Phone: 0300 123 6780
Email: Kathryn.Walsh@lancashire.gov.uk
Your ref: 3/2024/0862
Our ref: 3/2024/0862/HDC/KW
Date: 11 December 2024

Location: Higher Parsonage Farm Parsonage Lane Chipping PR3 2NS
Proposal: Proposal to enclose existing storage facility with timber cladding above two existing stone clad lower walls and double pitched roof over.
Grid Ref: 360613 441833

R. SEED & SON, PARSONAGE FARM – PLAN 4 a

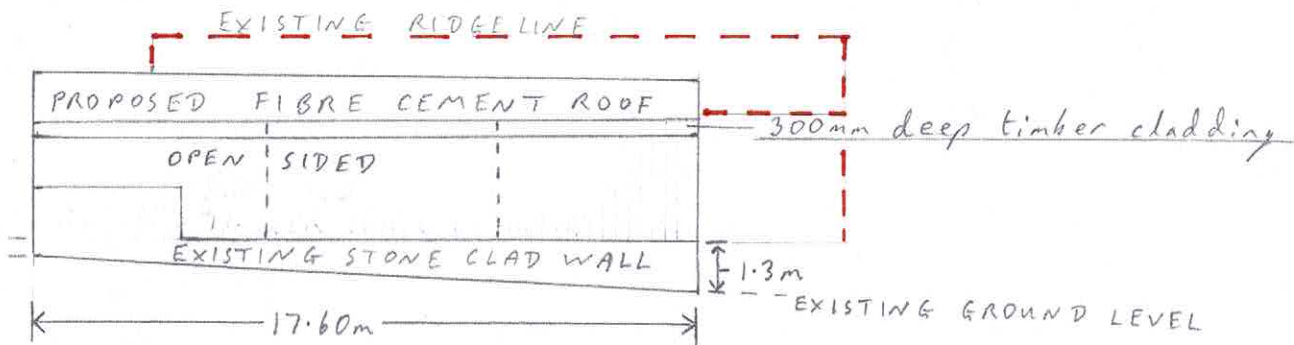
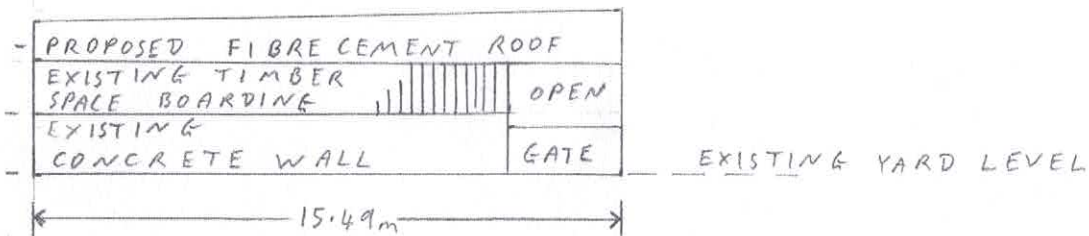
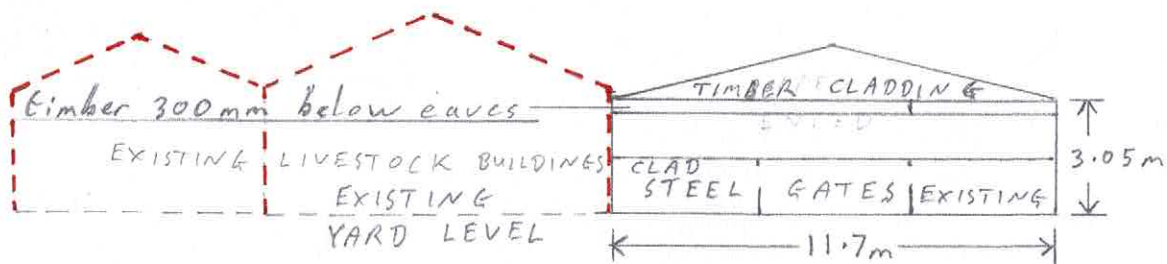
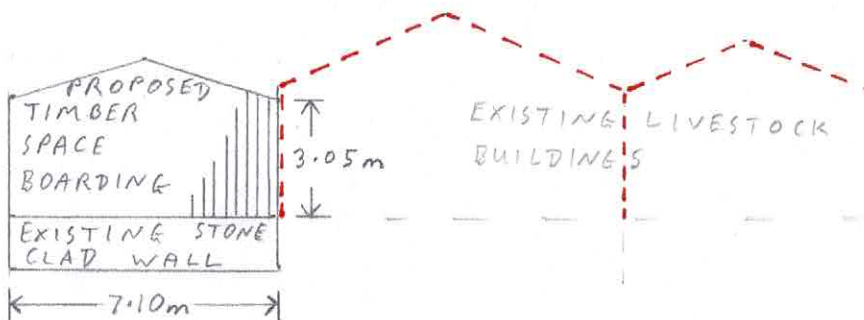
The LHA have reviewed the amended drawing titled R.Seed & Son, Parsonage Farm – Plan 4 A. The amendment has removed the close border fencing to south east elevation to retain the existing intervisibility between highway users and the agricultural vehicles using the existing site.

The drawing shows that whilst the visibility splay does pass through the proposed development, the amendment for the southeast side to remain partly open will allow vehicles to see through and observe highway users on the adopted highway as such the

effect of the development on the operation of the local highway network would be negligible.
